From: Simon Davis
Sent: 01 December 2021 12:05
To: Planning Scanning
Subject: FW: Drove Lane Sales Cabin refs Y/141/21/PL and Y/142/21/A

With respect to application Y/142/21/A (*Various advertisements in various locations, Land East of Drove Lane, Yapton*) , the Parish Council objects on the grounds that:

Item 3 - Quantity 1

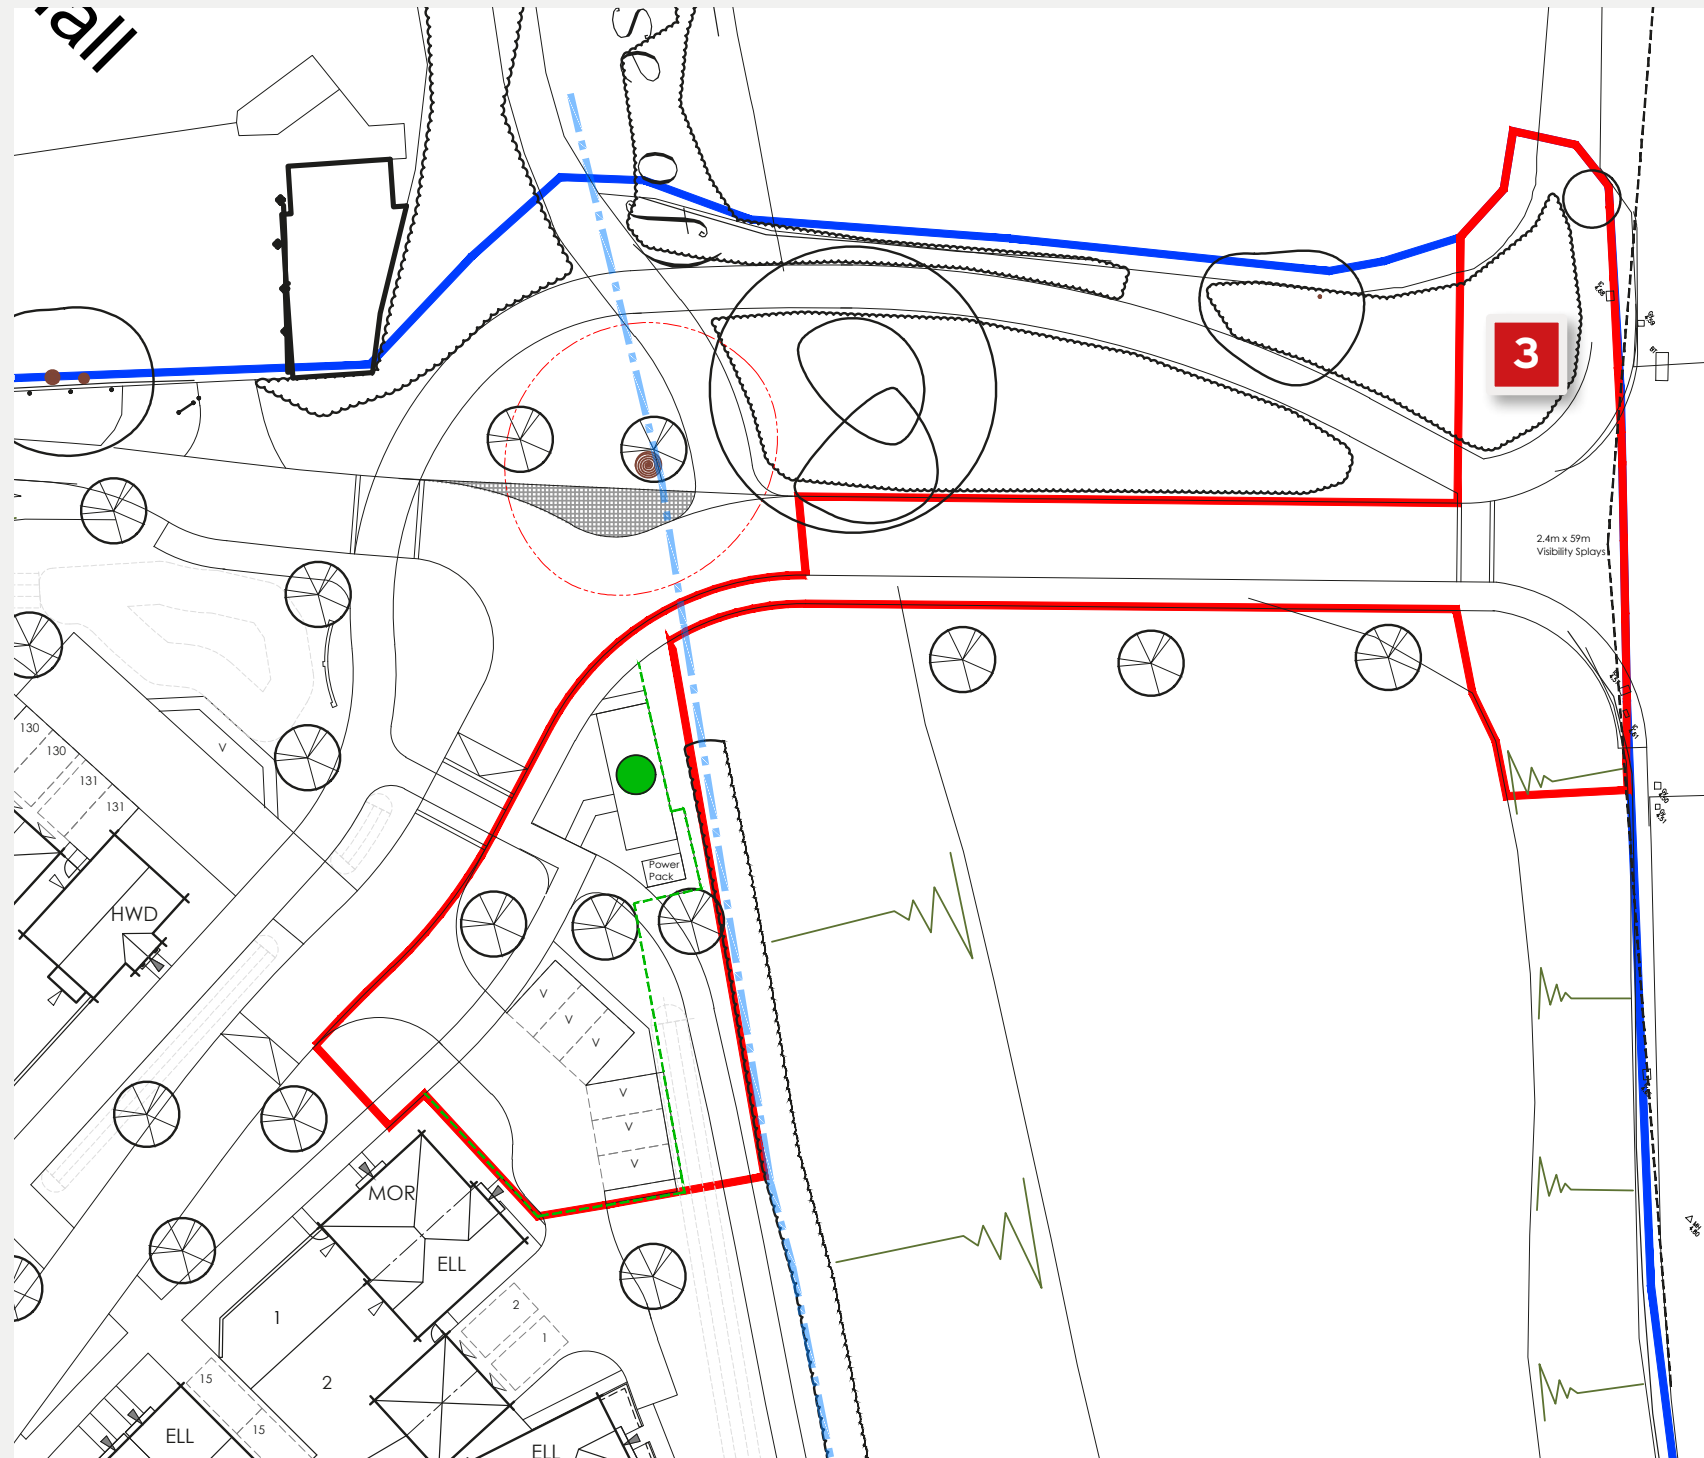
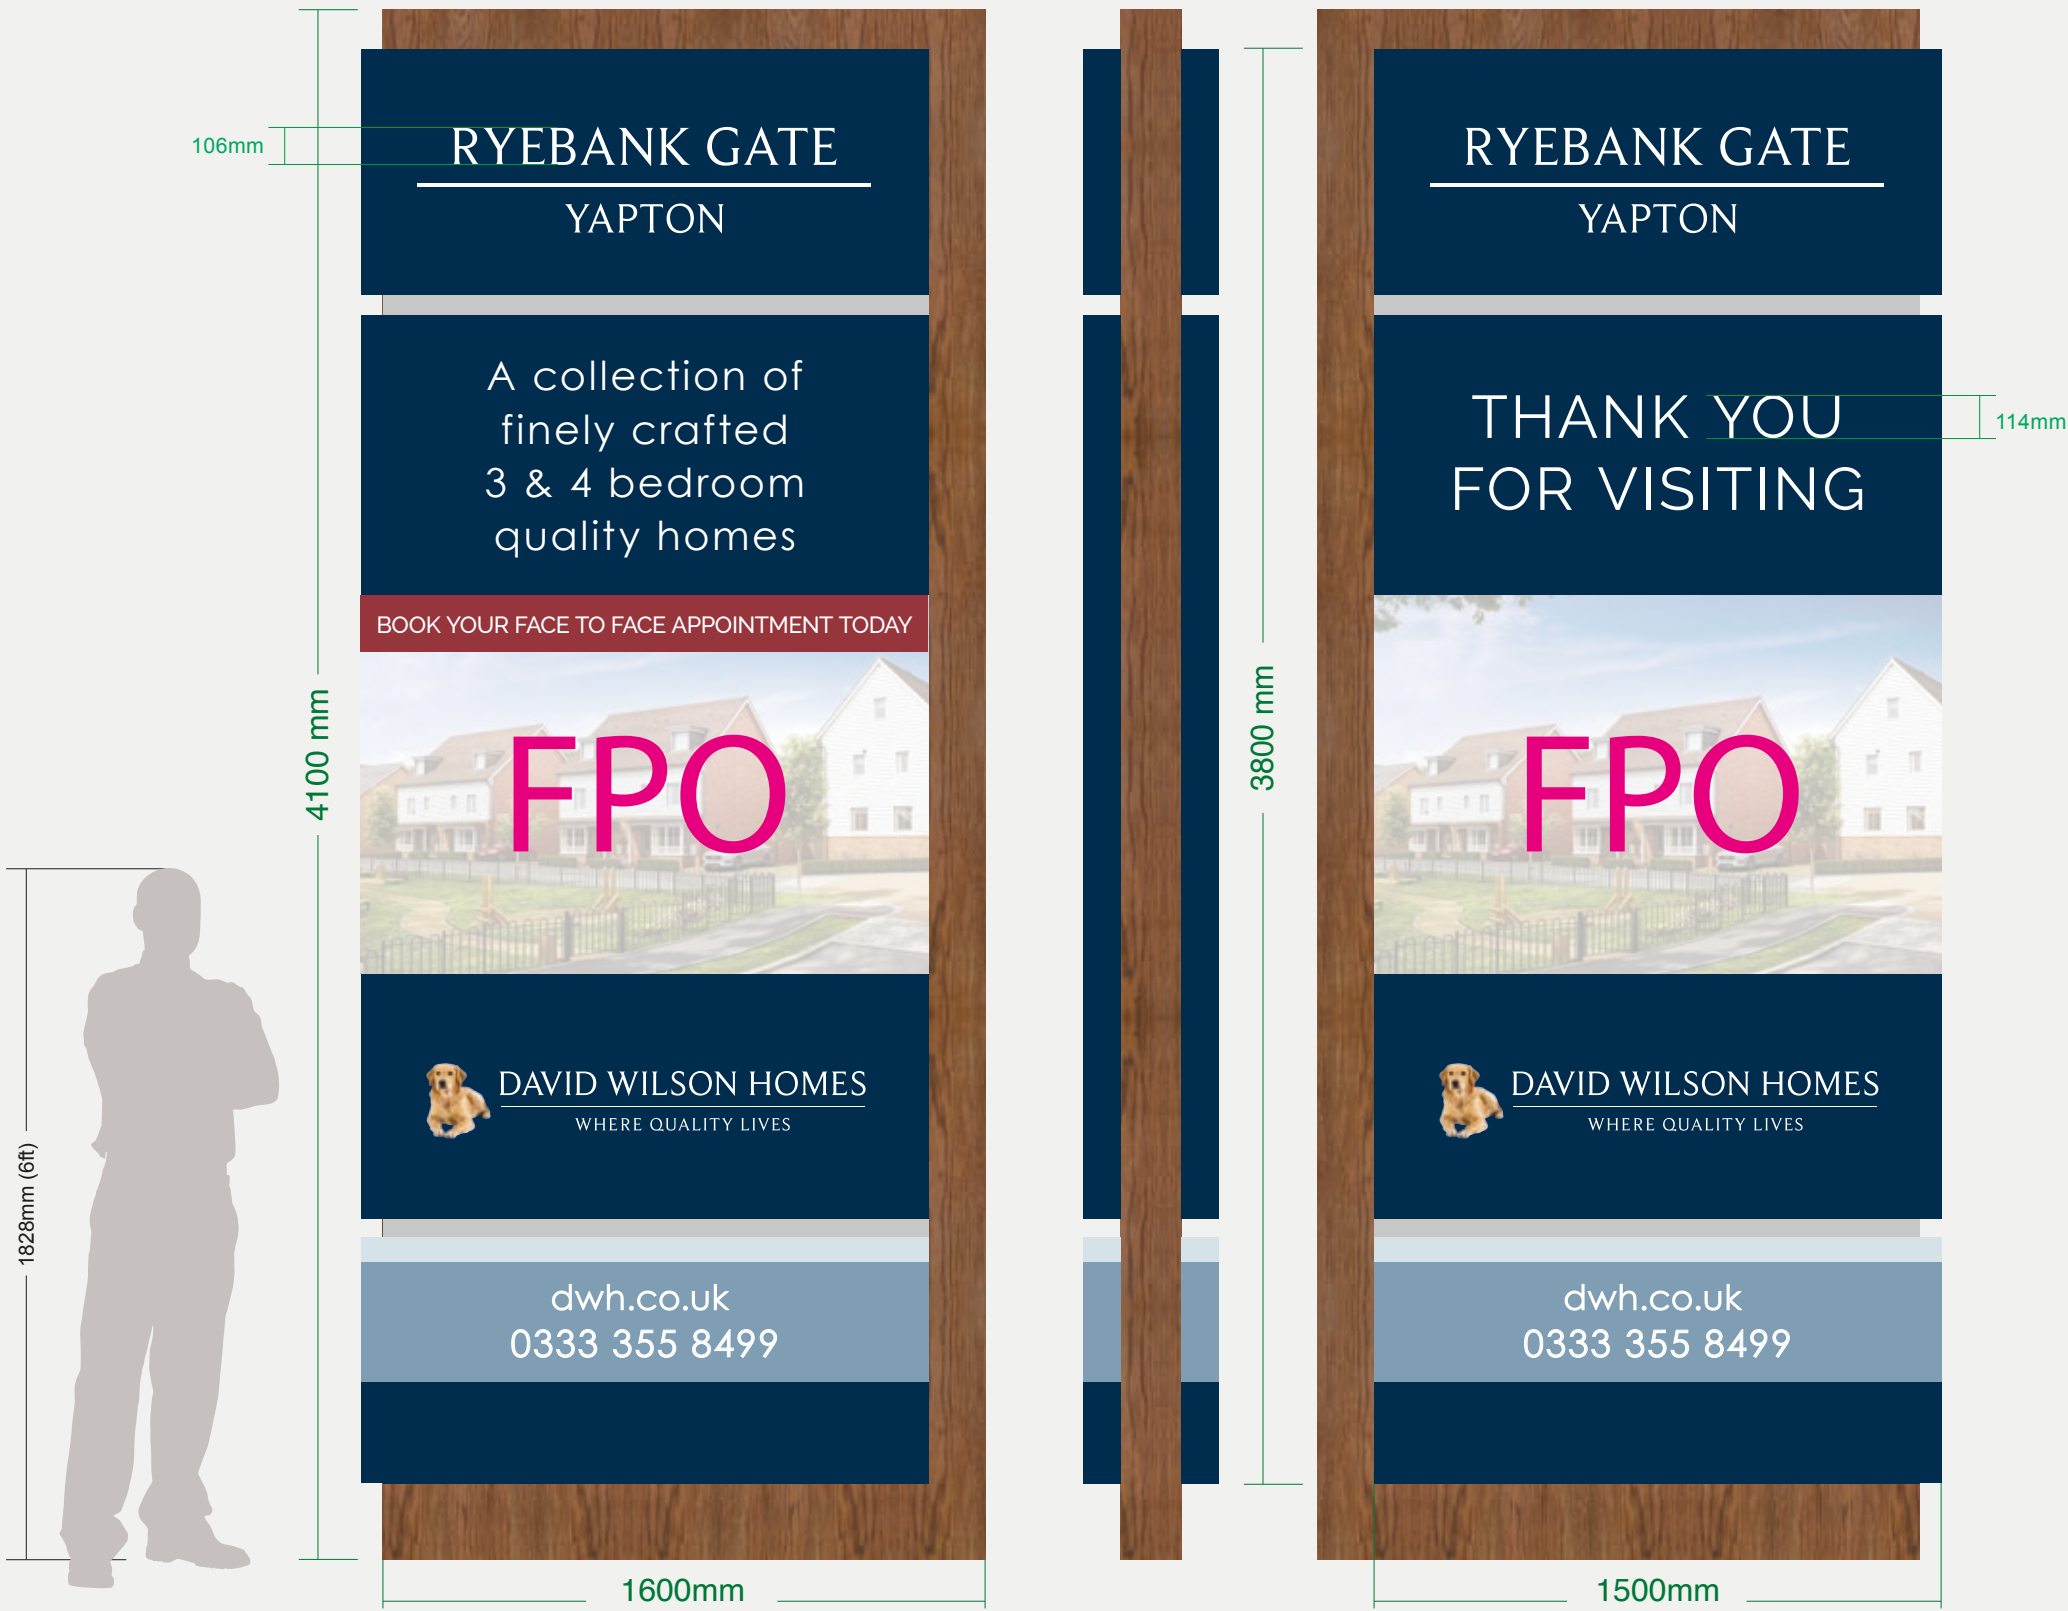
The concern is the level of signage fronting Main Road. By adding a further two 12 foot totems isn't going to remove or indeed lessen the clutter on the frontage. The Parish would strongly suggest the applicant simply has one totem and no more fronting the main road as per other house builders in Yapton. The Parish Council would request that the height restriction for the totem is no higher than 1.5m.
